Subject: Rezoning Petition Review

Date of Review: January 27, 2022 (*Revised February 25, 2022*)

Rezoning Petition #: 21-215

Location of Property: Approximately 102 acres located on the north side of Mt Holly Rd and west of Belmeade Dr.

SCHEMATIC  
SITE PLAN

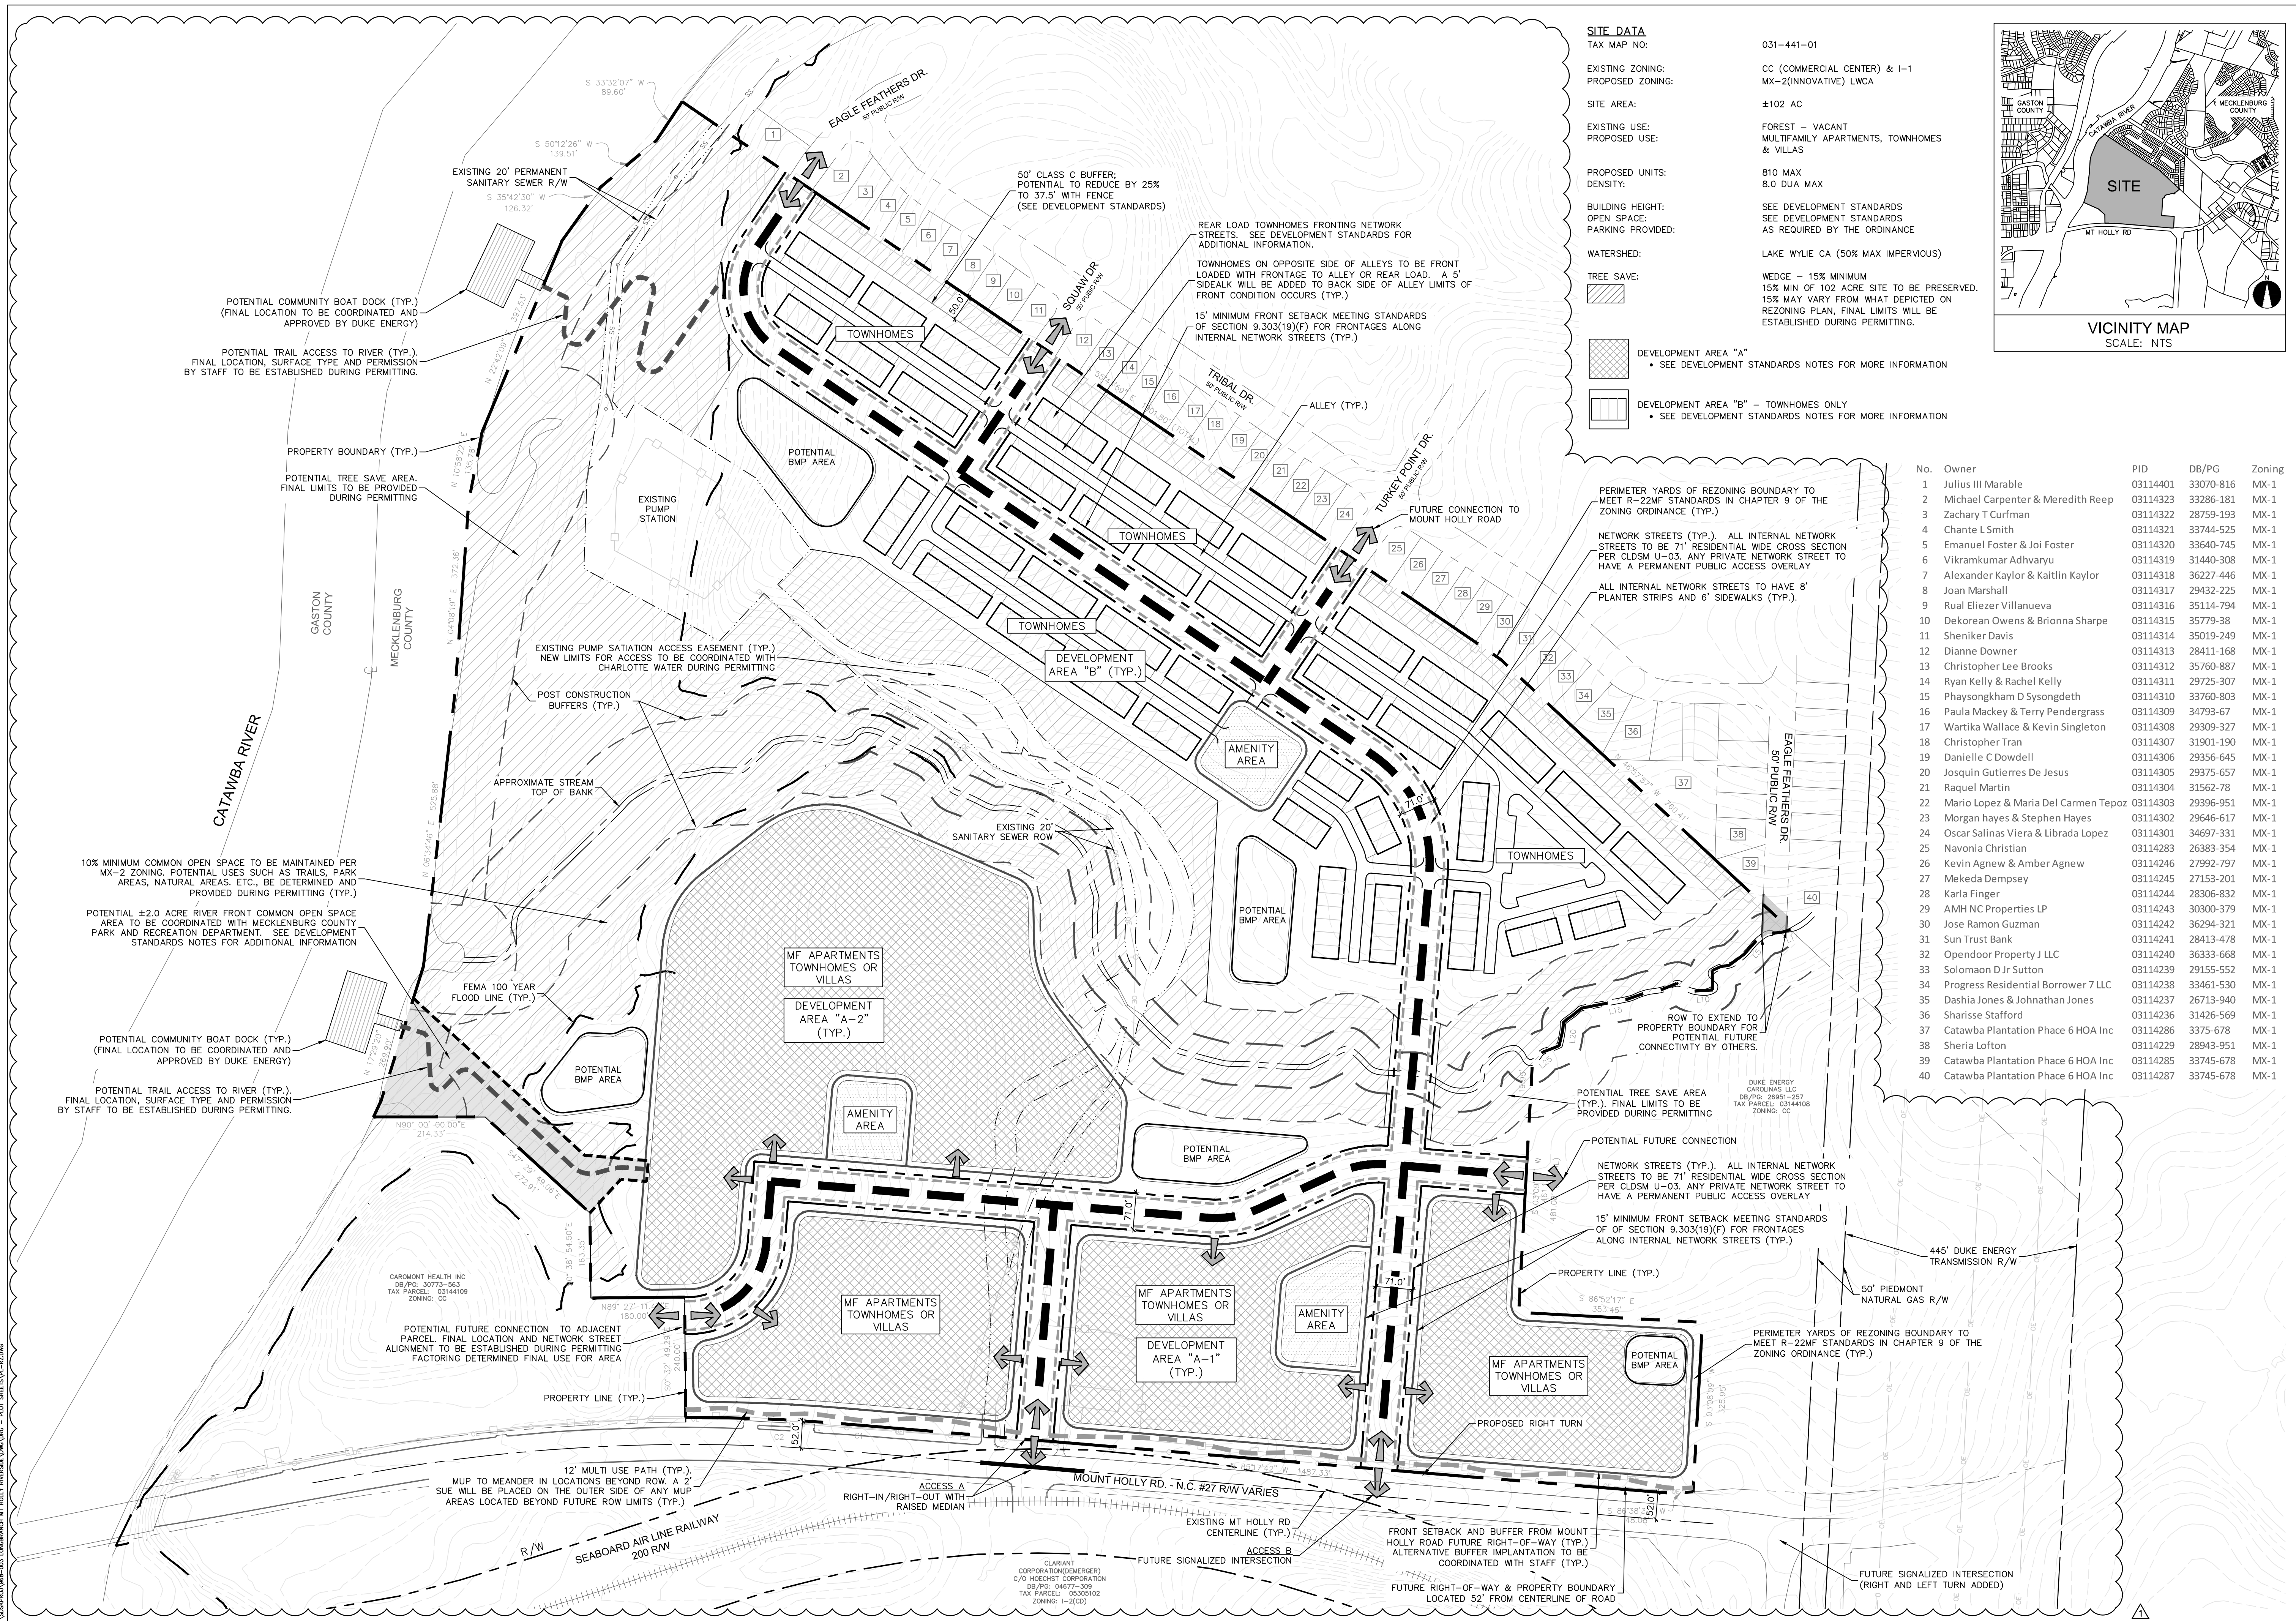
Please label (size and type) of all SWIM/PCSO buffers on site and include the following note on the site plans:

- Development within any SWIM/PCSO Buffer shall be coordinated with and subject to approval by Charlotte-Mecklenburg Storm Water Services and mitigated if required by City ordinance. Petitioner acknowledges intermittent/perennial stream delineation reports are subject to review and approval upon submission of development plans for permitting and are not approved with rezoning decisions.
